22 July 2020

**Supplementary Response to Submissions
Multi-Trades and Digital Technology Hub, TAFE NSW Meadowbank Campus, Meadowbank
Education and Employment Precinct (SSD 10349)**

Further Project Amendments

GFA AREAS SCHEDULE	
LEVEL	AREA
M-L1	1446.9 m²
M-L2	835.6 m²
M-L3	4369.6 m²
M-L4	1868.3 m²
M-L5	3056.0 m²
M-L6	1500.5 m²
Grand total: 6	13076.9 m²

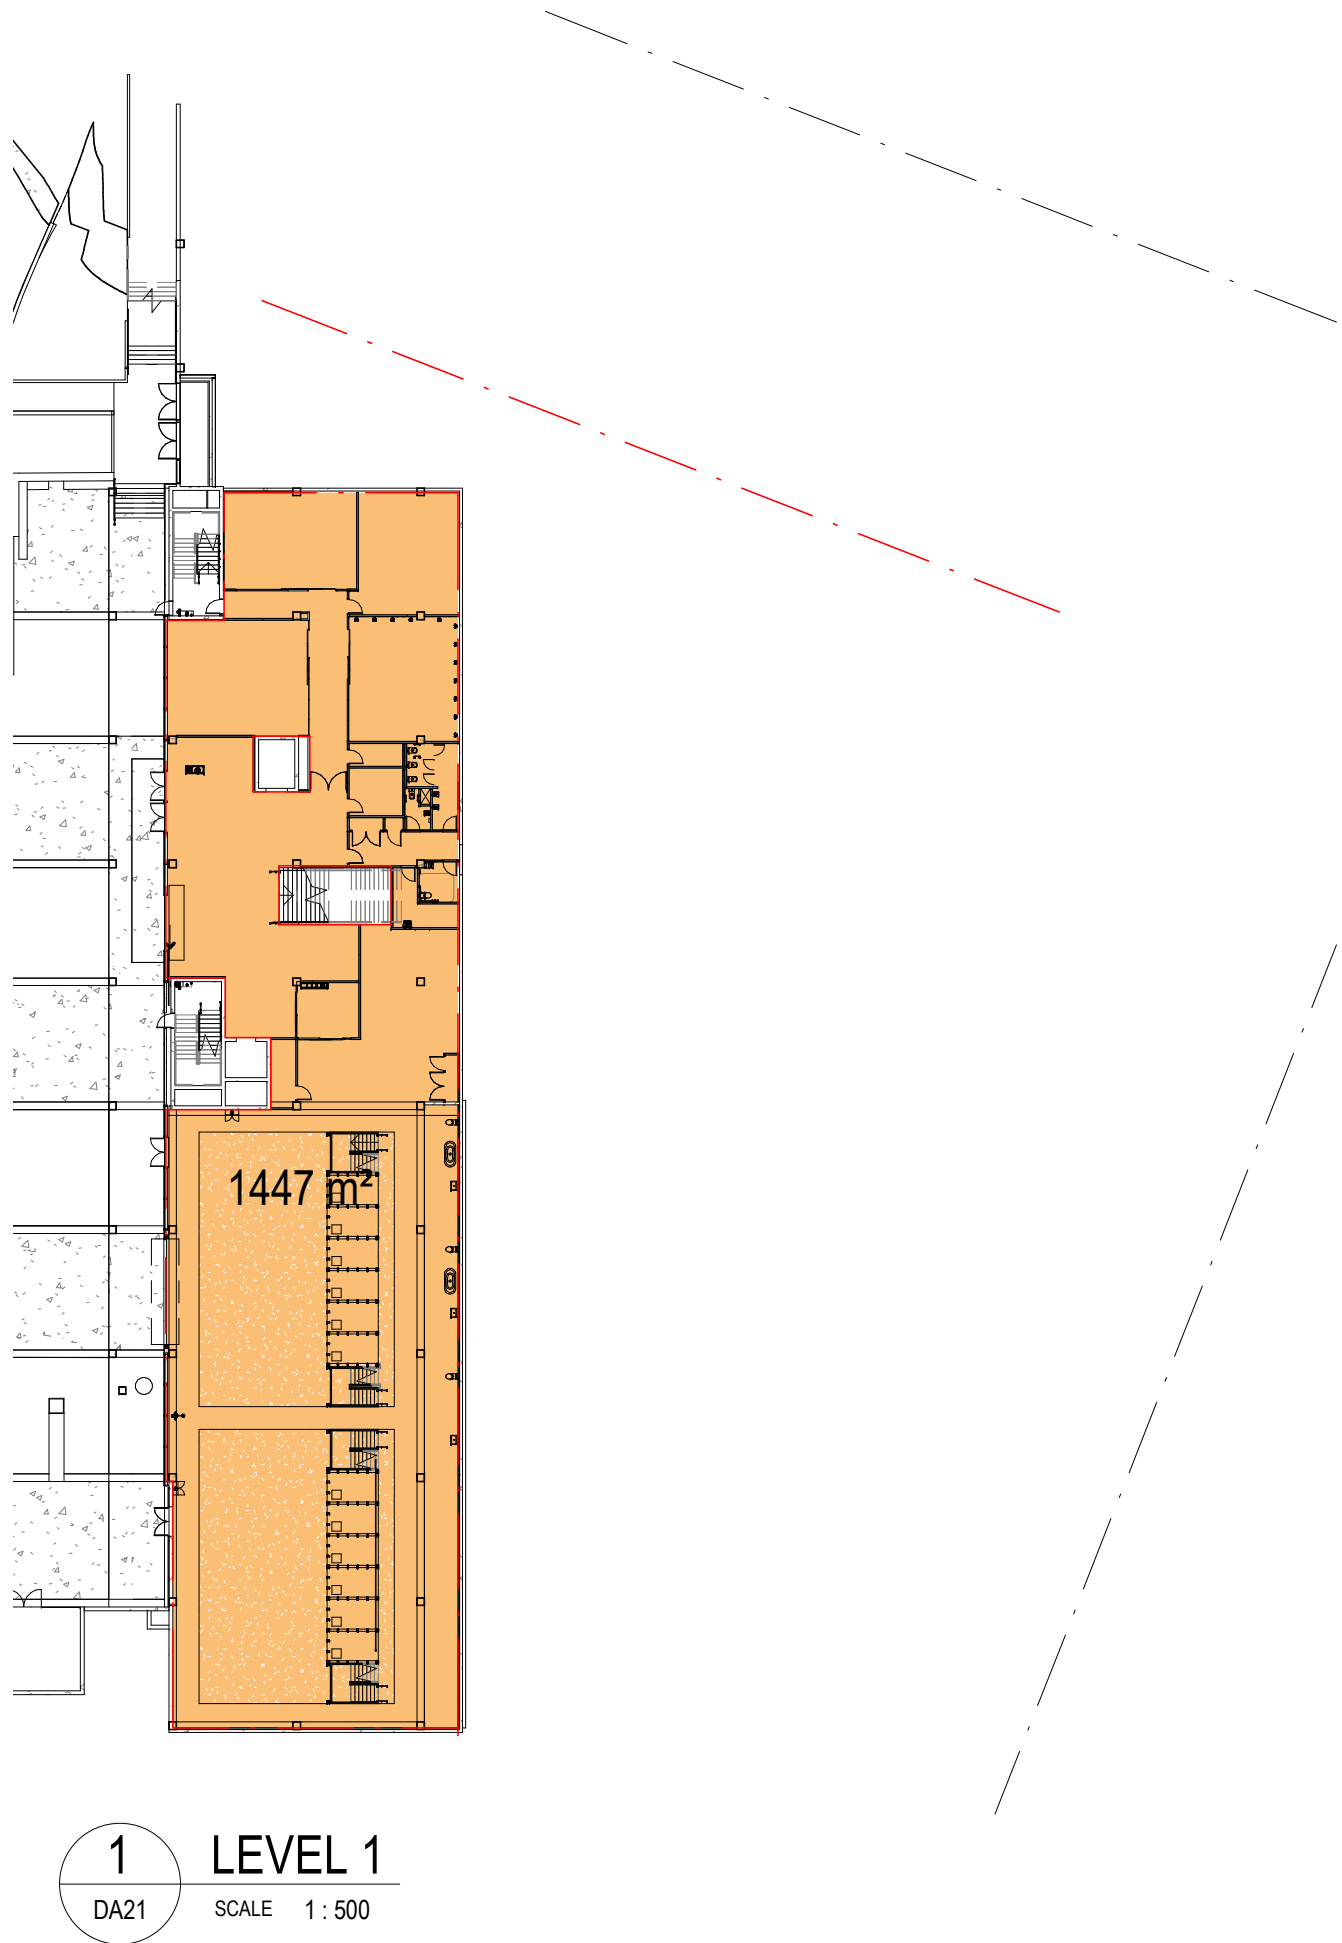
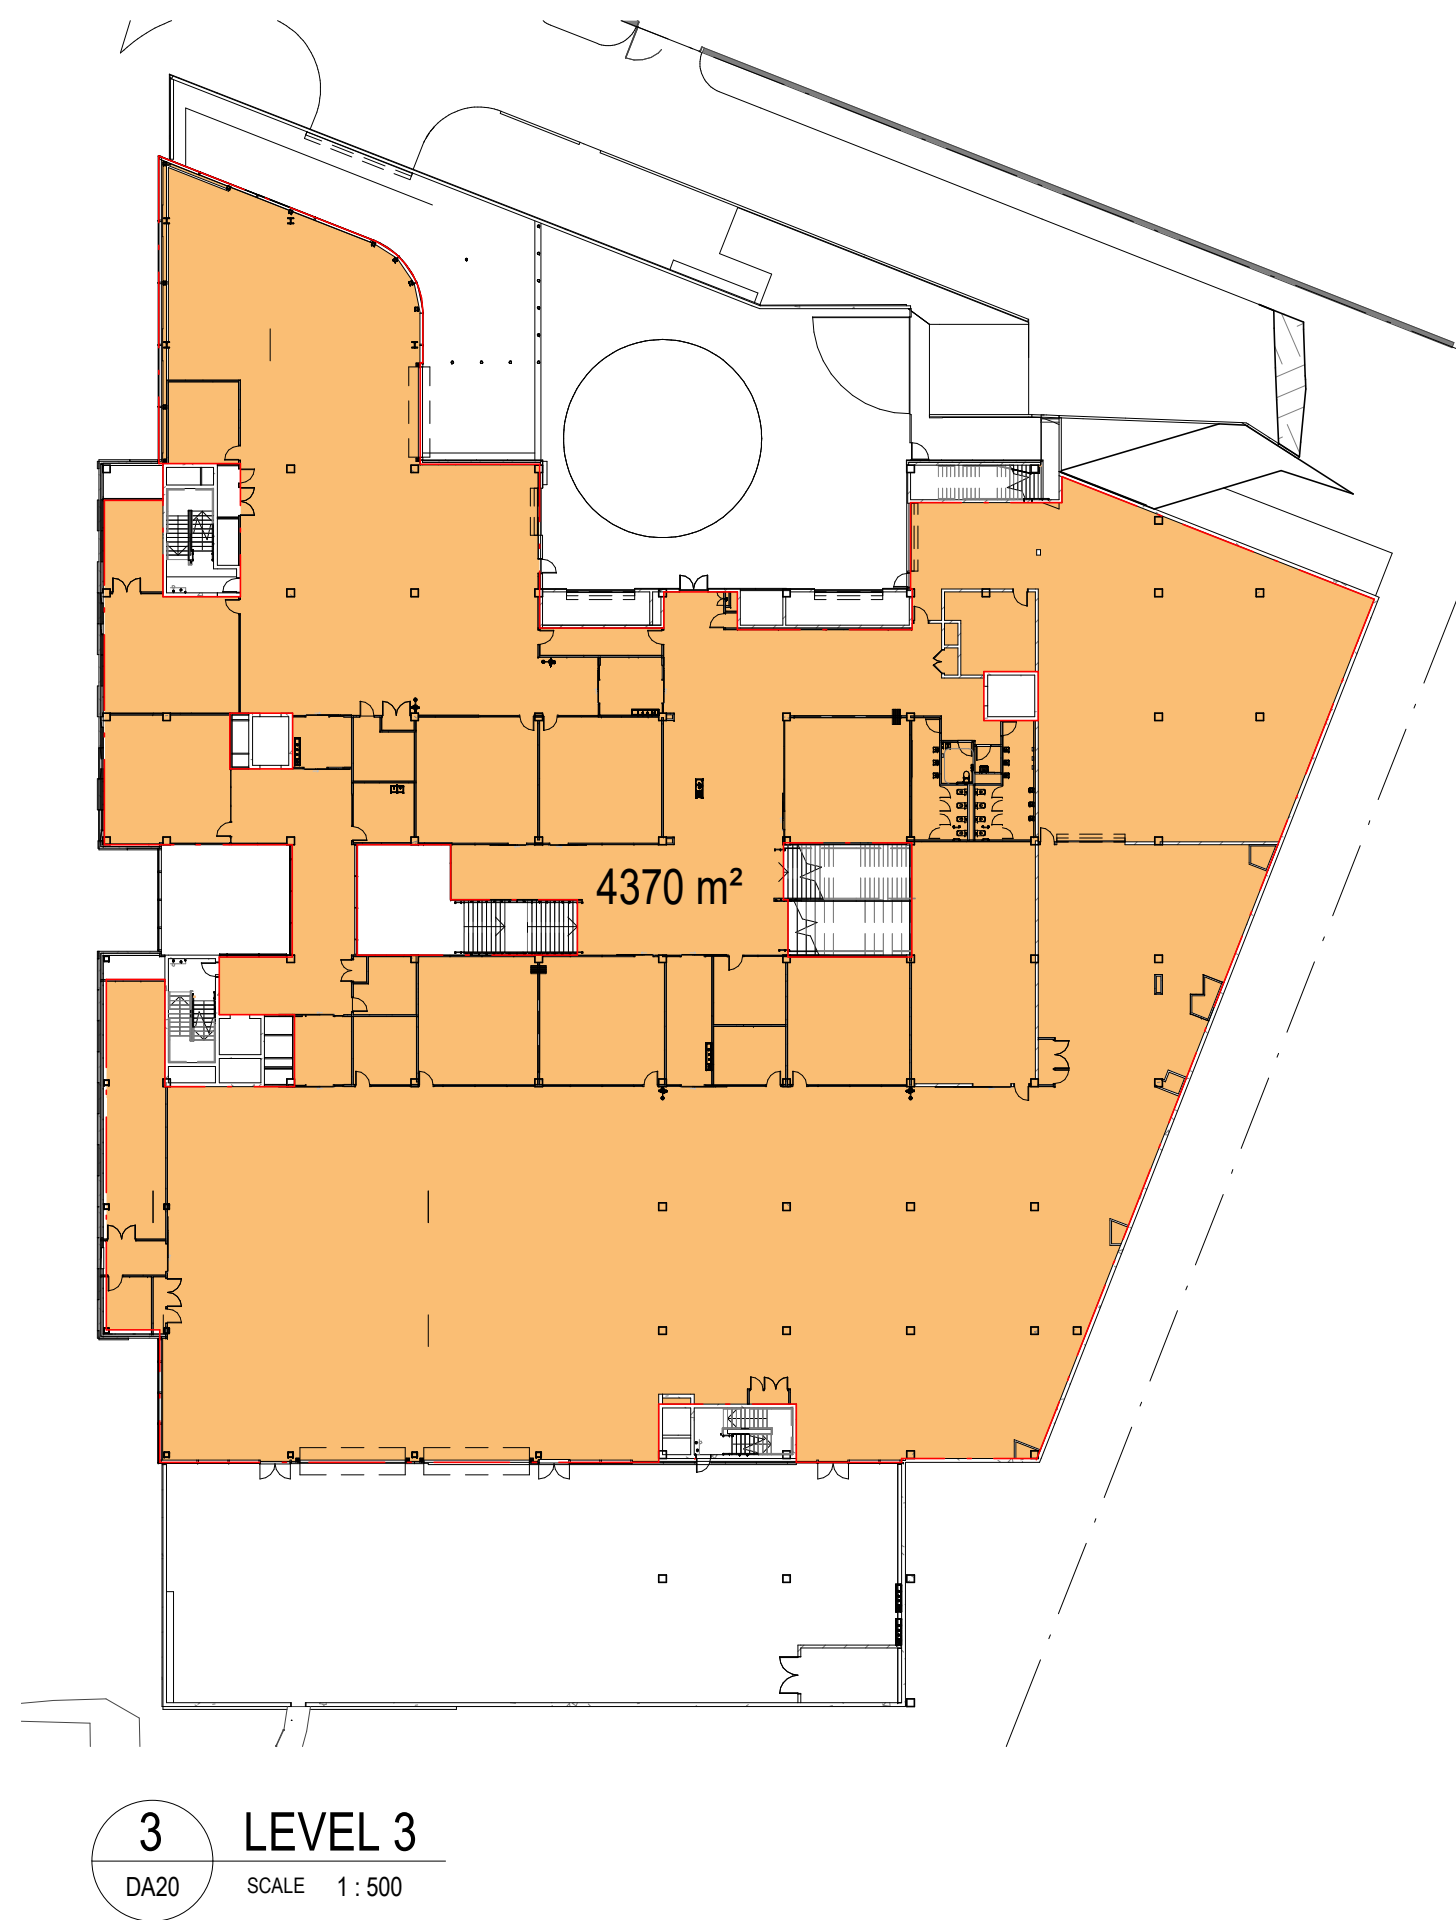
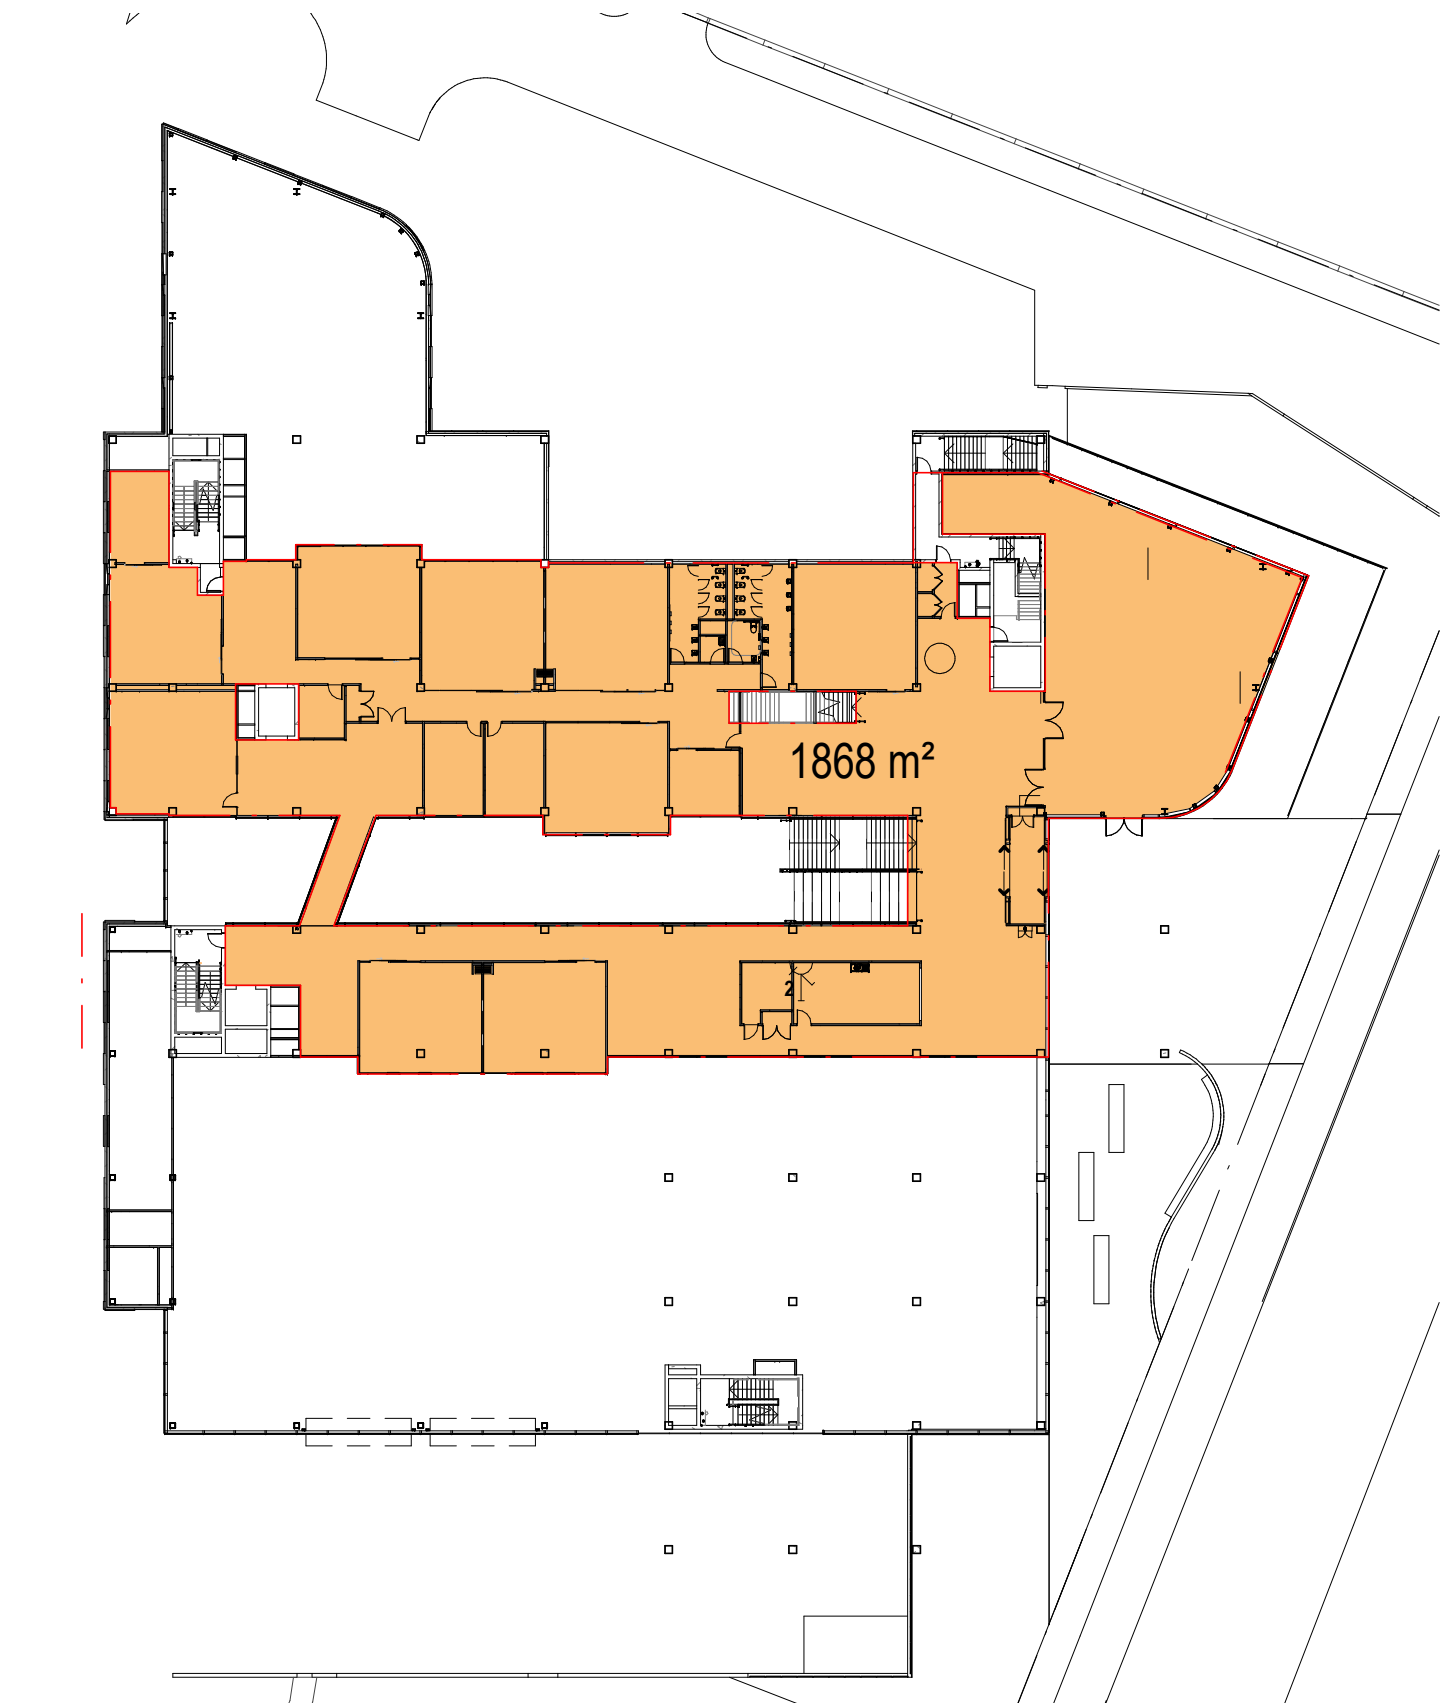
Plan Number	Revision	Date	TR-LA-DWG-C0100	2	12/06/20	219-0066-02_SSDA_100	3	29/01/20
Plan Number	Revision	Date									
TR-LA-DWG-C0100	2	12/06/20									
219-0066-02_SSDA_100	3	29/01/20									
A8	Confirm whether GFA Plan DA50 B needs to be updated.	<p>Drawing No. DA50 has been updated (Revision C and dated 08/07/2020) to reflect the amended layout of the Hub due to the introduction of the multi-storey car park.</p> <p>It is noted that the multi-storey car park is not included on this plan. In accordance with the definition of gross floor area included within the Educational Establishments and Child Care Facilities SEPP car parking is excluded for the purposes of calculating GFA.</p> <p>gross floor area means the sum of the floor area of each floor of a building measured from the internal face of external walls, or from the internal face of walls separating the building from any other building, measured at a height of 1.4 metres above the floor, and includes—</p> <ul style="list-style-type: none"> a) the area of a mezzanine, and b) habitable rooms in a basement or an attic, and c) any shop, auditorium, cinema, and the like, in a basement or attic, but excludes— d) any area for common vertical circulation, such as lifts and stairs, and e) any basement— <ul style="list-style-type: none"> (i) storage, and (ii) vehicular access, loading areas, garbage and services, and f) plant rooms, lift towers and other areas used exclusively for mechanical services or ducting, and g) car parking to meet any requirements of the consent authority (including access to that car parking), and h) any space used for the loading or unloading of goods (including access to it), and
